RE: CHECKER @ COORS AND LOS VOLCANOS (J10/D28) ENGINEER'S
CERTIFICATION SUBMITTAL FOR CERTIFICATION OF OCCUPANCY
APPROVAL. ENGINEER'S STAMP DATED 1-18-99

RE: REVISED DRAINAGE PLAN FOR CHECKER AUTO-COORS BLVD. (J10-D28)
REVISION DATED 8/18/98

RE: DRAINAGE PLAN FOR CHECKER AUTO-COORS BLVD. (J10-D28) ENGINEER'S
STAMP DATED 5/6/98

Re: Checker Auto — Los Volcanos and Coors(J10-D28) Grading and Drainage Plan for Building Permit

CHECKER AUTO - COORS BLVD.
GRADING AND DRAINAGE PLAN

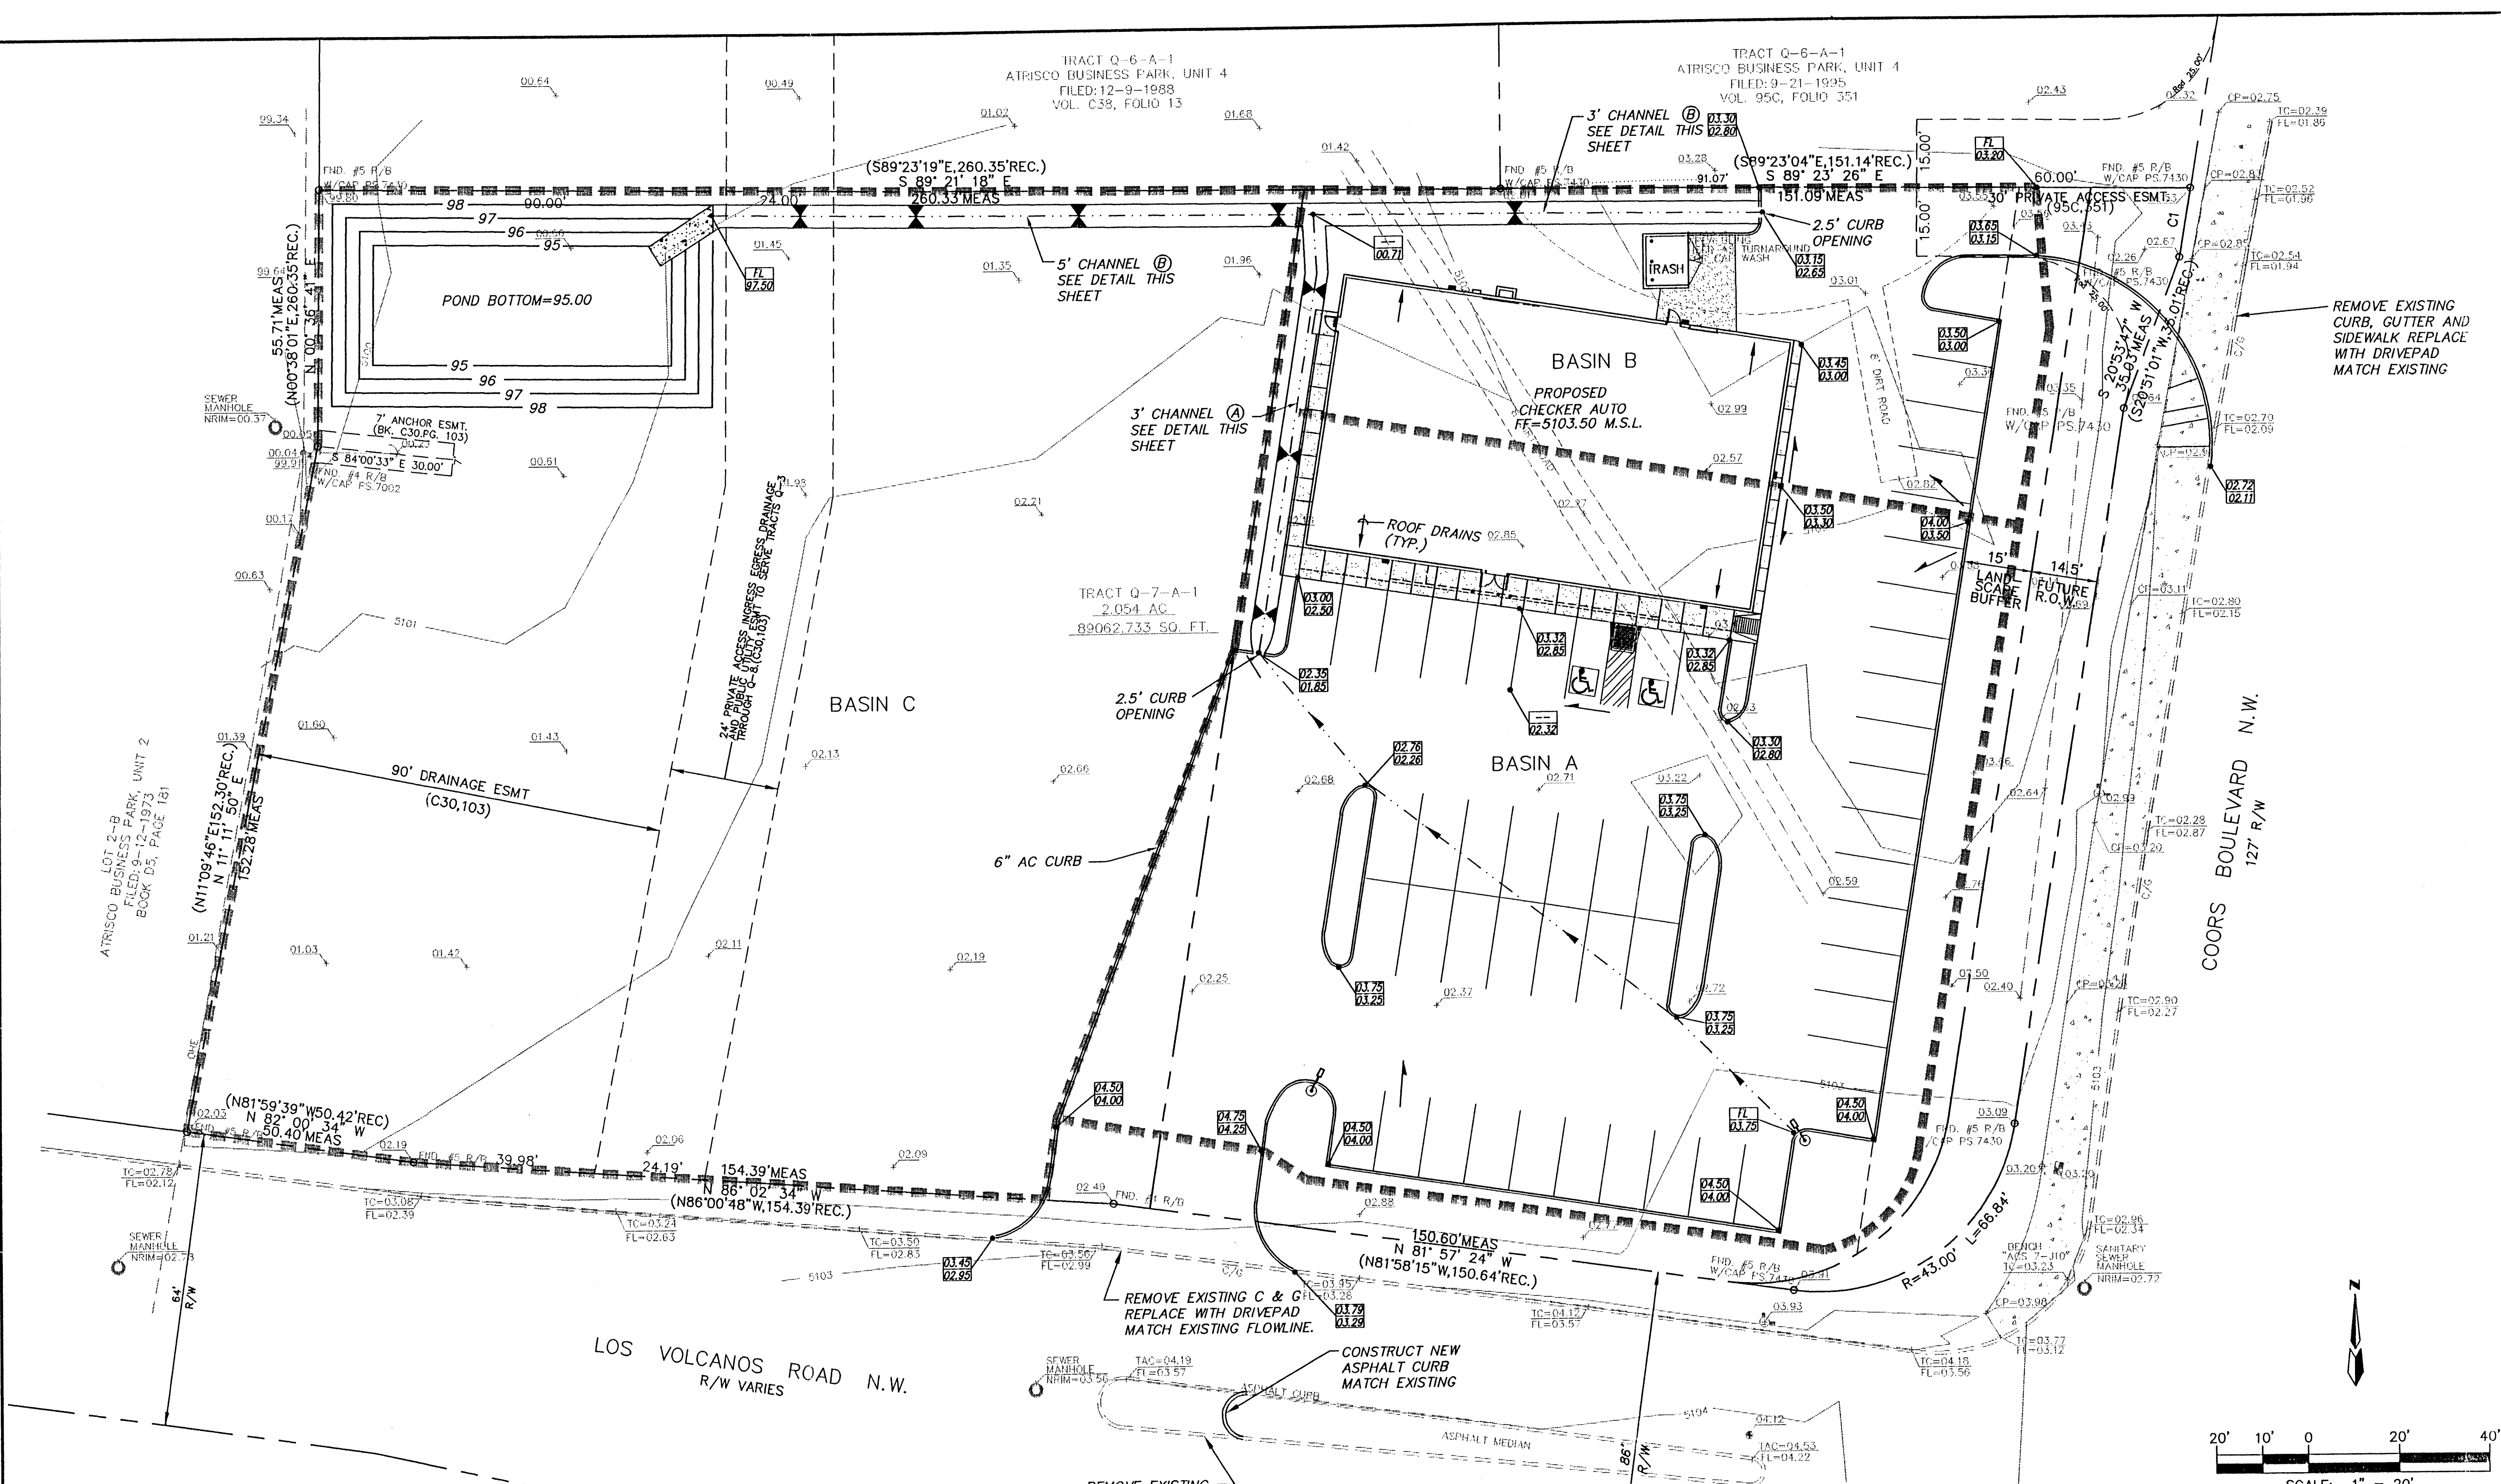
1. How will the interim design be eliminated when the West Bluff system is completed ?
2. You need to identify the final concept.
3. Will ponding be required after the West Bluff system is installed ?
4. Location and direction of roof drains.
5. One foot water block at the drivepads, at both ends.

1. A narrative was added to the drainage information portion of the plan explaining that the retention pond will be eliminated and the asphalt swales will be modified to tie in to the future west bluff drainage system.
2. A narrative explains the final concept of free drainage to the future West Bluff system by modification to the swales.
3. The added narrative explains that the ponding will be eliminated with the construction of the future West Bluff Drainage System.
4. Roof drains have been added
5. One foot water blocks have been added.
